## Engineers Comments Regarding Surface Water Drainage

<b>Application Reference:</b>	LU/93/25/PL	<b>Reviewer Reference:</b>	ADC/EXT2/D2134/75
<b>Planning Officer:</b>	Emma Sheppard	<b>Date of Review:</b>	03.09.2025
<b>Site Name:</b>	Units 5-7 Watersmead Business Park Norway Lane/Worthing Road Littlehampton BN17 6LS		
<b>Application Description:</b>	Part demolition, conversion, refurbishment and re-elevation of Units 5 and 6 and construction of retail (food and non-food), leisure and food & beverage units (Use Class E), together with associated car parking, access, loading areas, landscaping and associated works. This application is in CIL Zone 2 and is CIL Liable.		
<b>Assessment Number:</b>	1

PERMEABLE PAVING COLLECTION PIPE DETAILS (NOT TO SCALE)

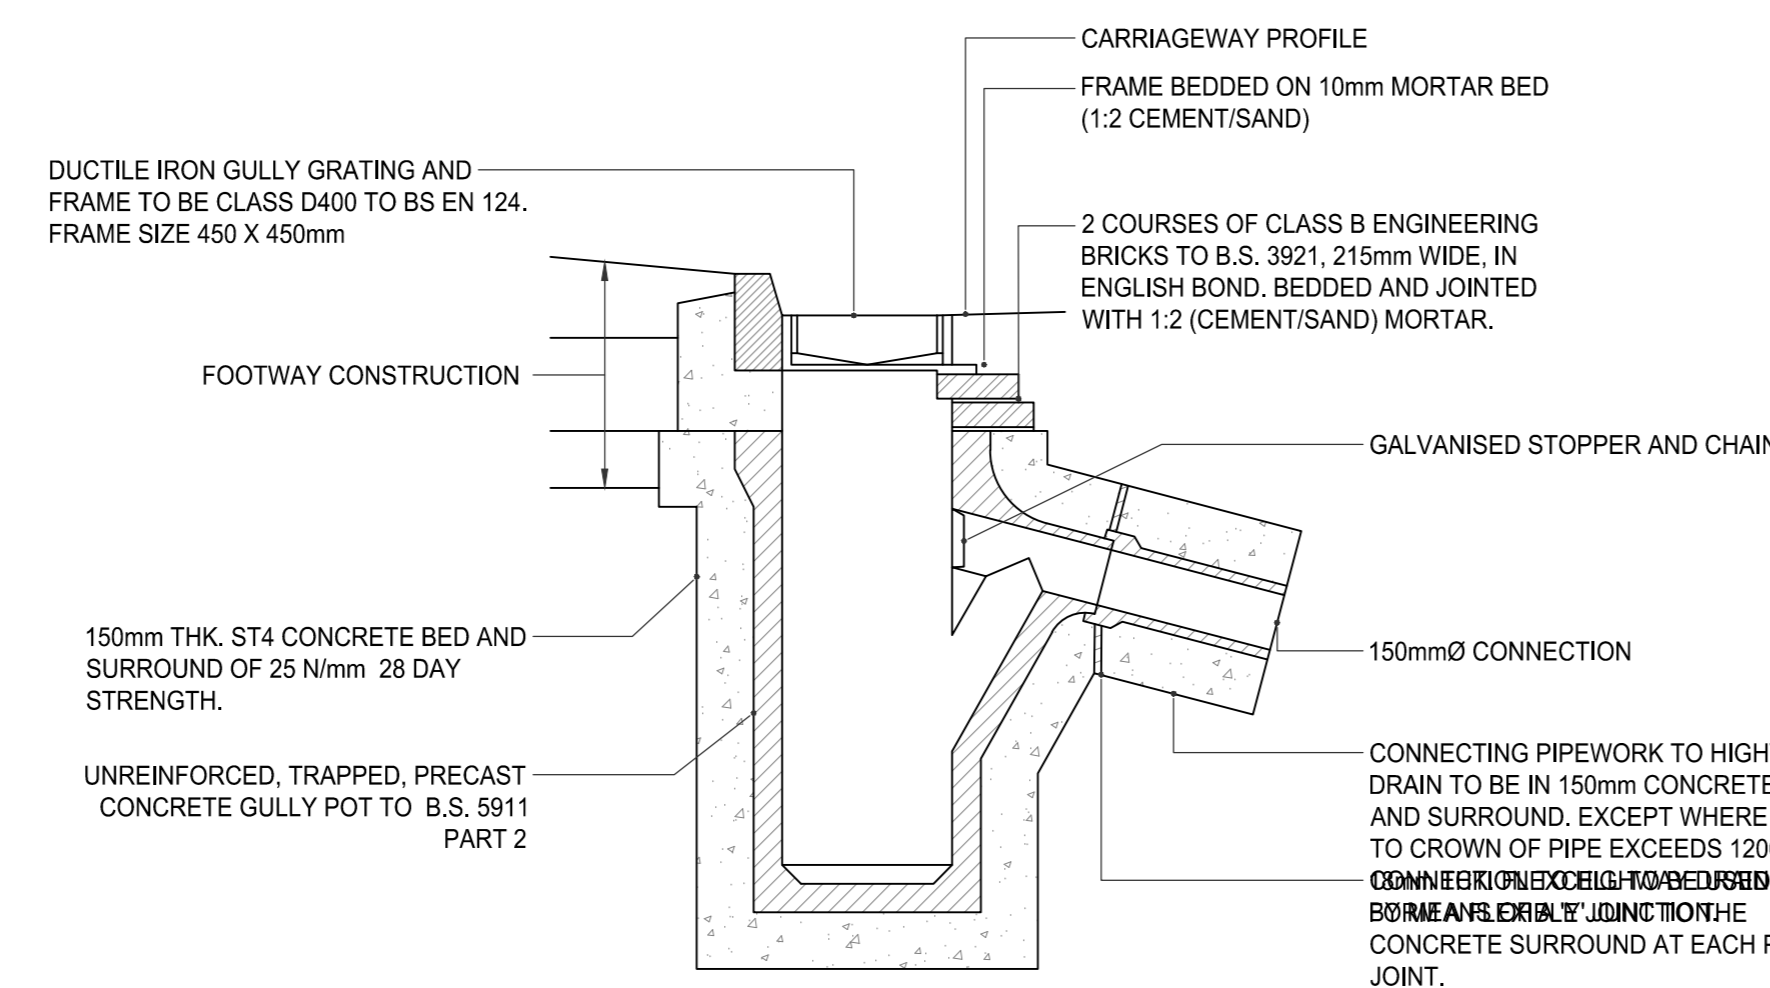
The proposed drainage layout drawing 02300/P02 highlights areas of the car park to be tanked permeable pavement. Noting the levels proposal on drawing 02100/P0 these features are located on elevated parts of the site hence will provide little benefit in draining the hard standing areas or providing complaint water quality for ALL run-off.
